# SKETCH PLAN AMENDMENT FALCON HIGHLANDS

SKETCH PLAN AMENDMENT

PCD File Skp 21-4  
**RESPONSE: Added**

SKETCH PLAN AMENDMENT FALCON HIGHLANDS

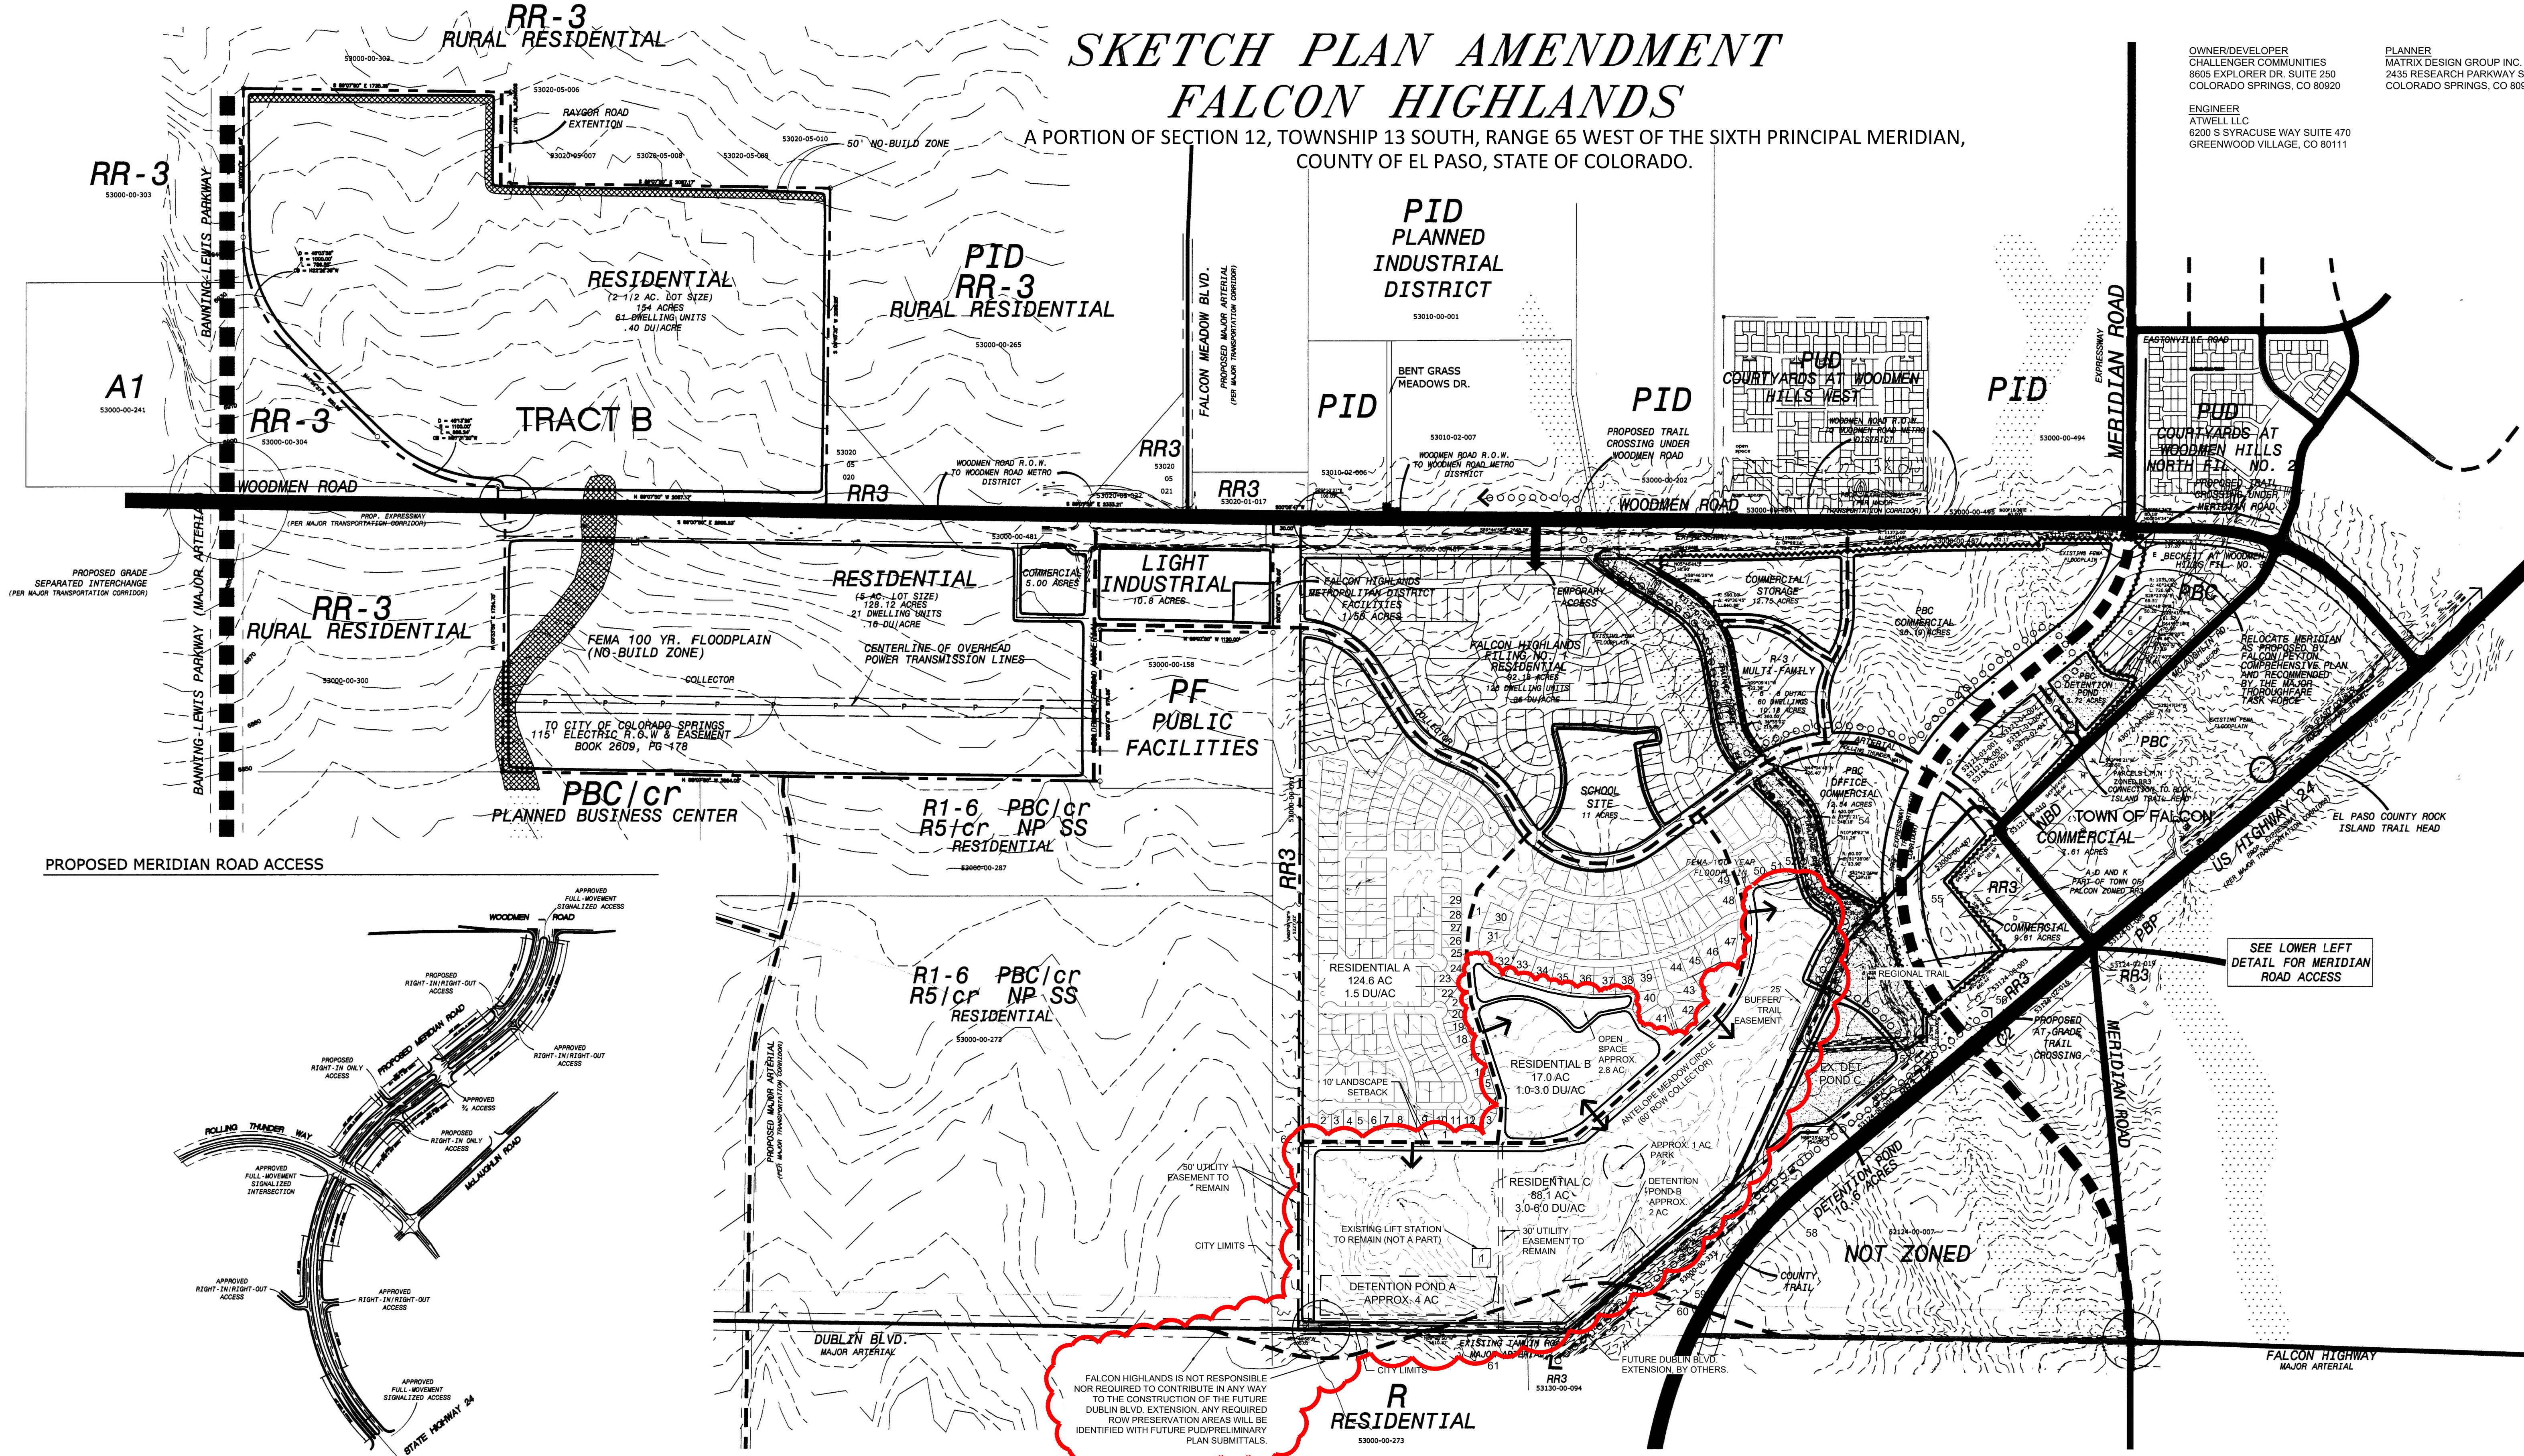
Is Dublin here or left on western prop. line? Note to west if that is the case w the leader and label a dashed thick line as future Dublin ROW extension.

bring the red cloud down so these lot owners don't think your amending their properties.

there is also a 1-to-2 acre park in addition to the openspace buffer between the existing lots and the amended area

**RESPONSE:** Per discussion with staff Dublin Blvd is shown based on current information. A note has been provided indicating Dublin Blvd will be built by others.

**RESPONSE:** Updated as requested

**RESPONSE:** The park site was added to the cover sheet and shown as 1 acre. Final design will determine size and shape.

SKETCH PLAN AMENDMENT FALCON HIGHLANDS

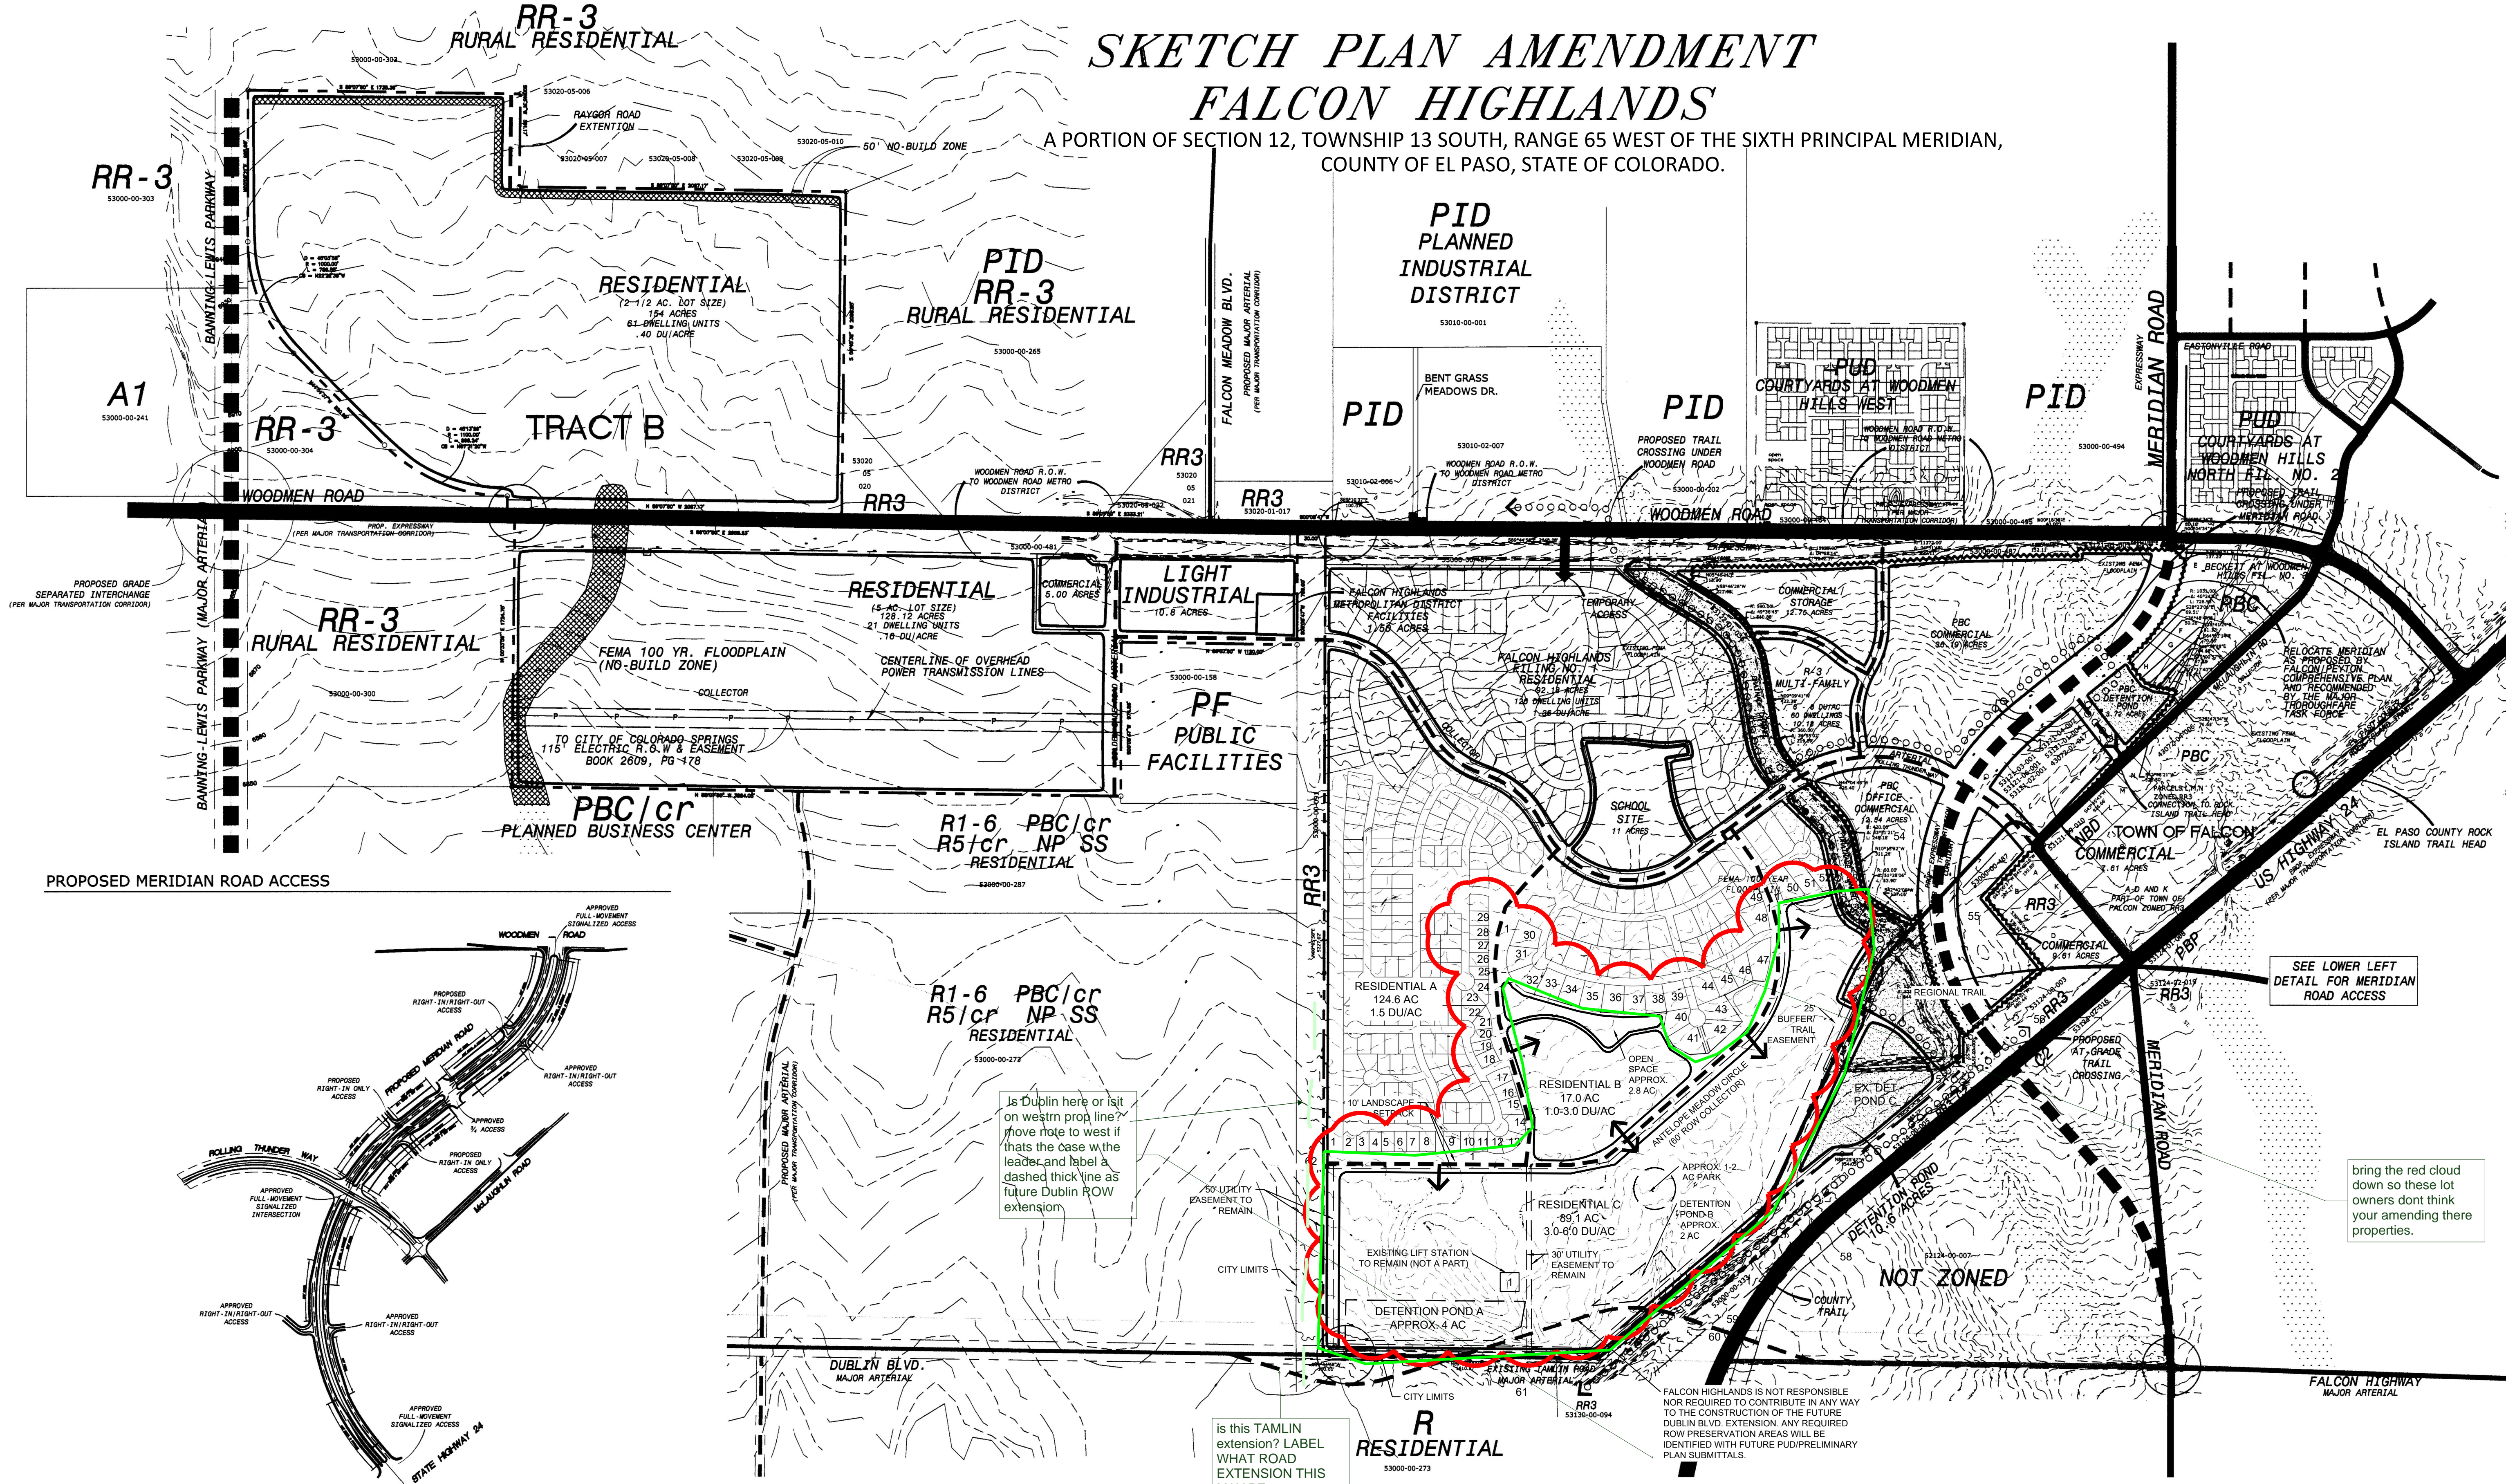
is this TAMLIN extension? LABEL WHAT ROAD EXTENSION THIS MAY BE

delete Maximum for the phasing notes 1-3 in case FHMD obtains water (add increase in units per phase does not trigger a SKP amendment)

delete this note because this is what will be approved if BOCC is SUBJ approved

**RESPONSE:** Updated to remove Filing 3 as requested

**RESPONSE:** Removed
